PROJECT TITLE: Broadstone Santa Monica ZONE MAP/DRG.FILE# D-18-Z
DRB#: _____ EPC#: _____ WORK ORDER#: _____

Re: Broadstone Santa Monica—D18/D054

This letter is in reference to your comments for the referenced project dated 4/2/12 (attached). Please see below for responses to your comments.

**Re: Broadstone Santa Monica Place
Grading and Drainage Plan
Engineer's Stamp dated 3-7-2012 (D18/D054)**

CG1.2
GRADING AND DRAINAGE PLAN
NW QUADRANT

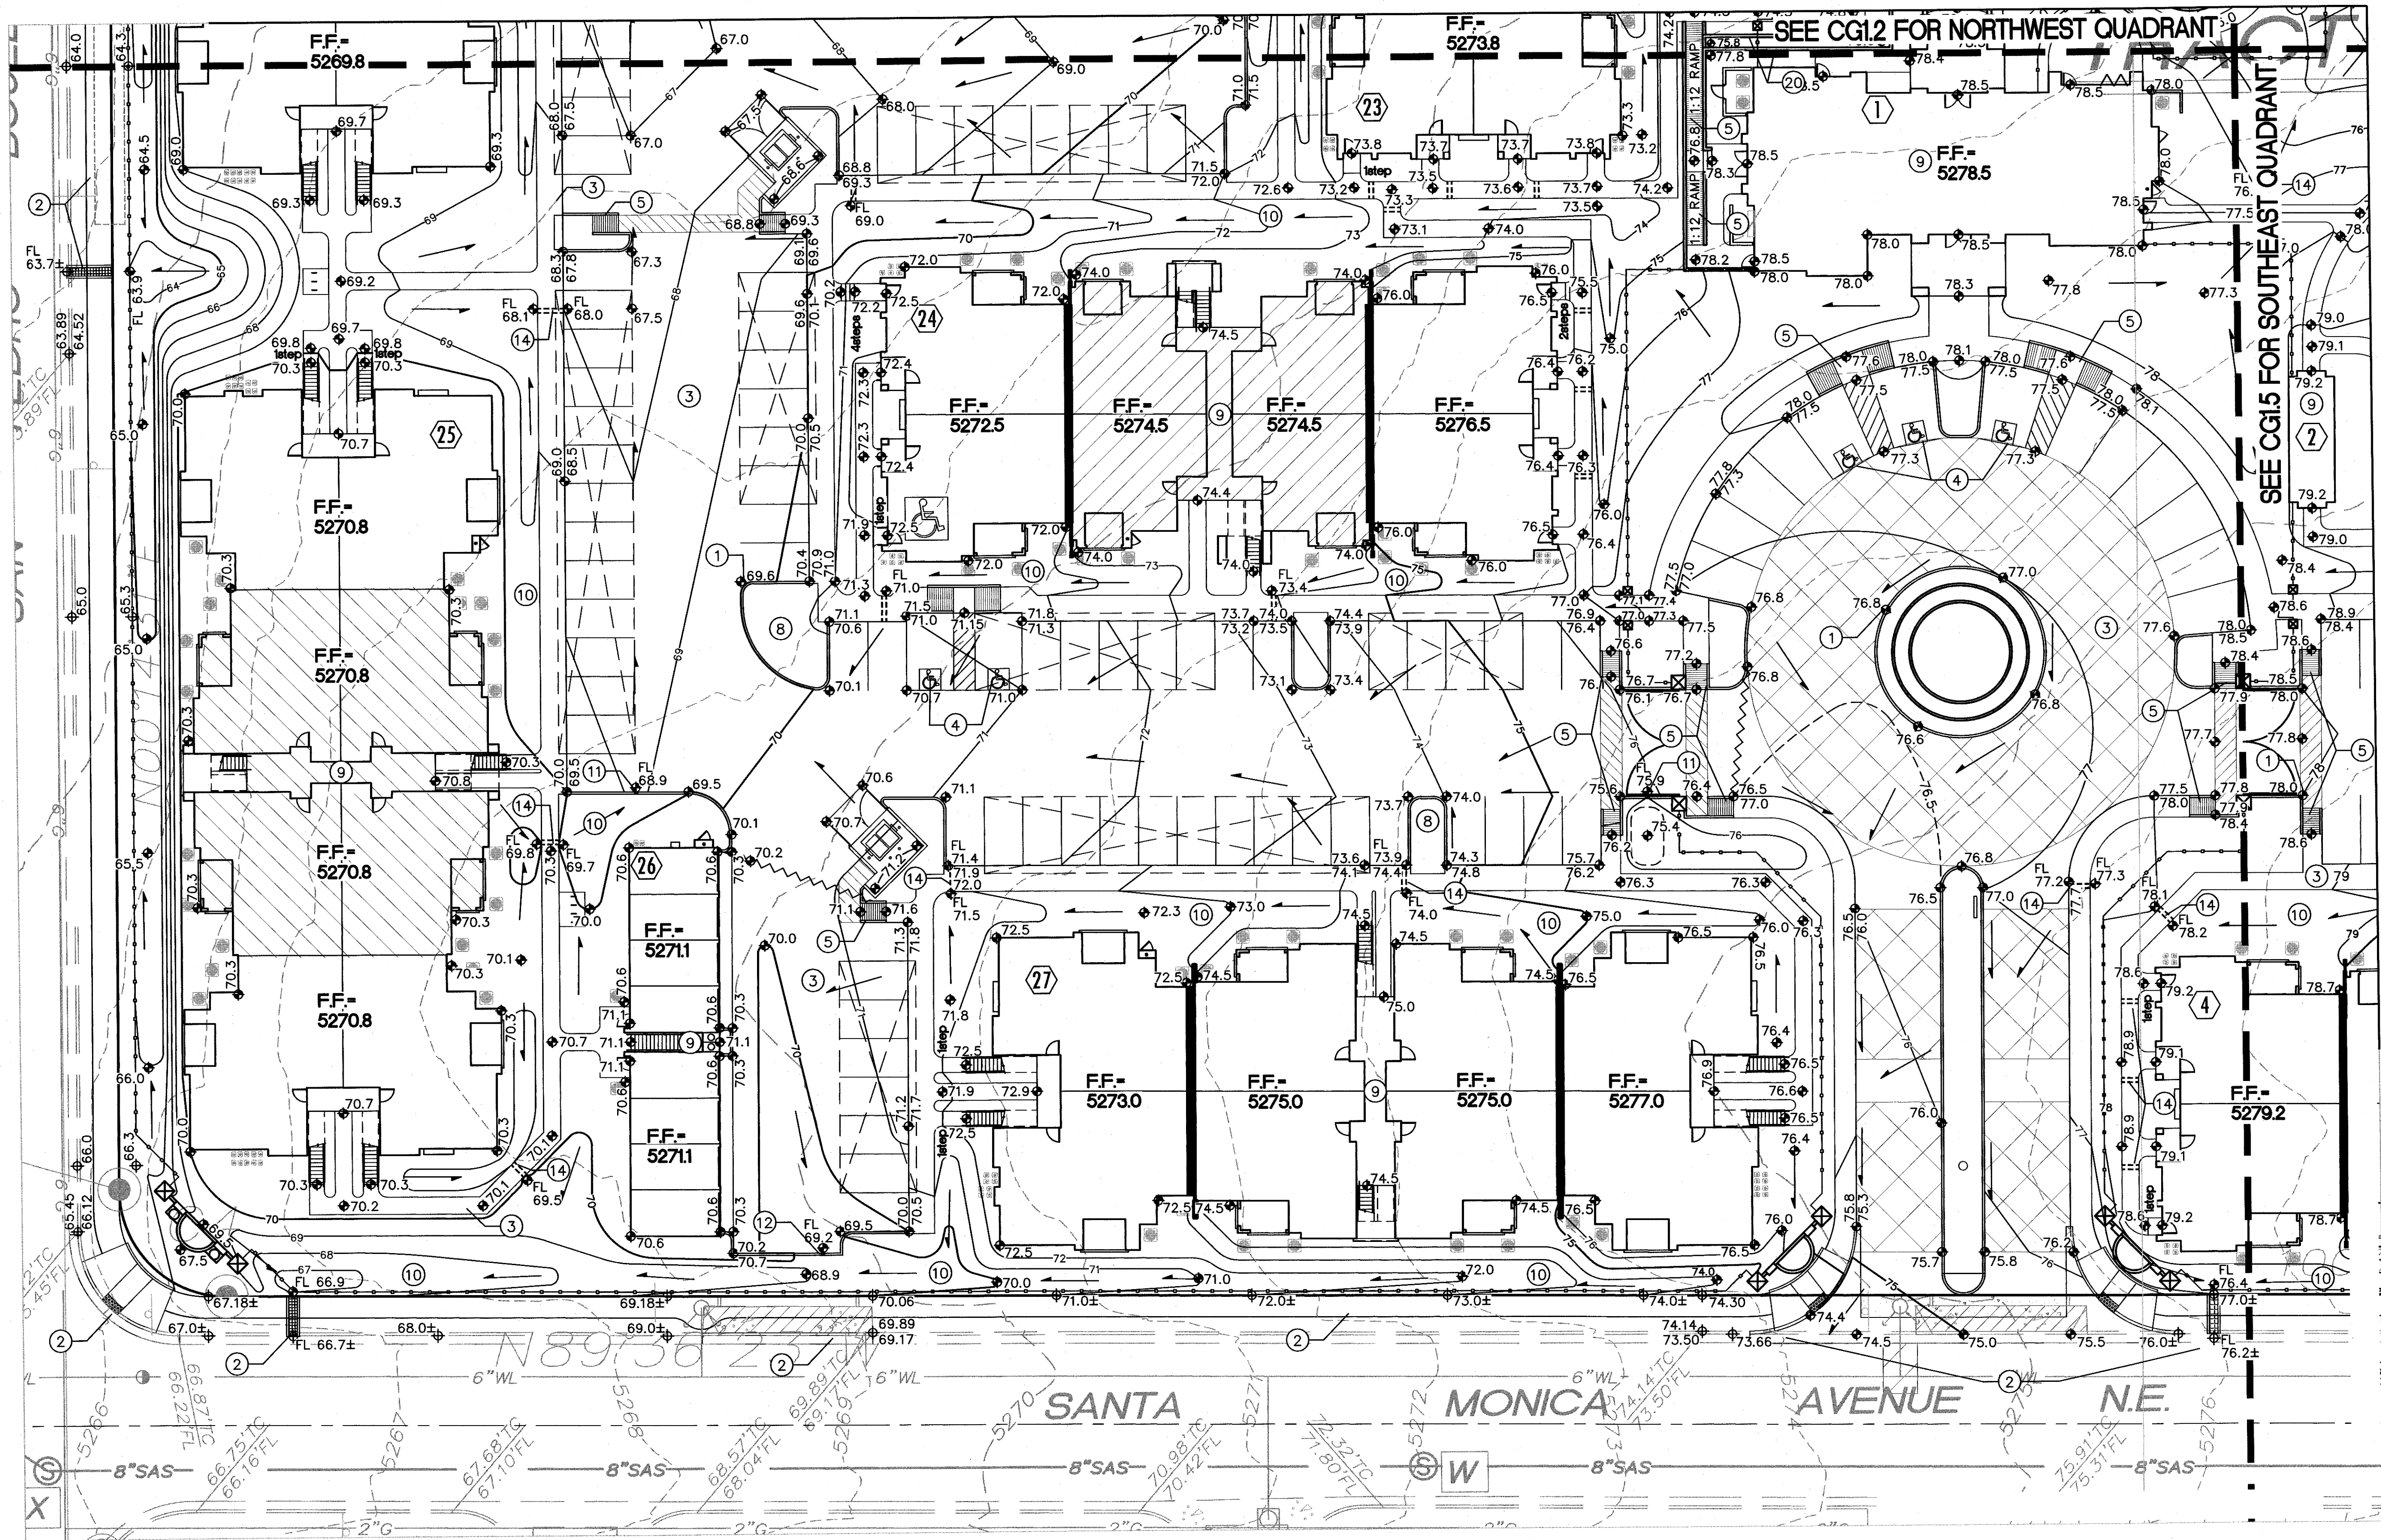
- Pond calculations are needed for the small pond just north of the entrance/exit on San Pedro. What is the WSE?
- How are the proposed contours tying in with the contours to the north of this site at the NW corner?
- Provide the direction of roof flows for the units in the NW corner. These flows should not drain over the sidewalk.
- Are all landscape areas being depressed as well as the areas with sidewalk culverts? Can the small islands in the parking lots contain a 1' cut in the curb to accept flows? This would assist in lowering the flows entering San Pedro for the first 6 hours and would also help with the new EPA regulations and the MS 4 permit coming in the near future.

1. The intent of the storm drain outfall structure is to dissipate the velocity of the storm drain discharge and overflow it to the south paved drive over a 6.5-foot wide weir. Flow remaining in the lower 6 inches will pass to the north via the proposed 4-inch drainline. The peak flow in the 4-inch pipe is 0.5 cfs and the remaining flows of 21.0 cfs discharges via the weir. See Supplemental Calculations for weir overflow and 4-inch orifice calculations. Based on these calculations, the water surface elevation will be 63.0—one foot above the flowline elevation. The curb adjacent to the weir will be 12 inches high with transitions to the top of wall elevation of 64.5.

2. Off-site contours have been referenced on the plan to clearly show the grade transition to the north. This includes the area at the northwest corner of the site.

3. All units have pitched roofs which drain to all sides. A shallow swale has been added on the west side of the northwest corner unit to pass roof discharge to the north.
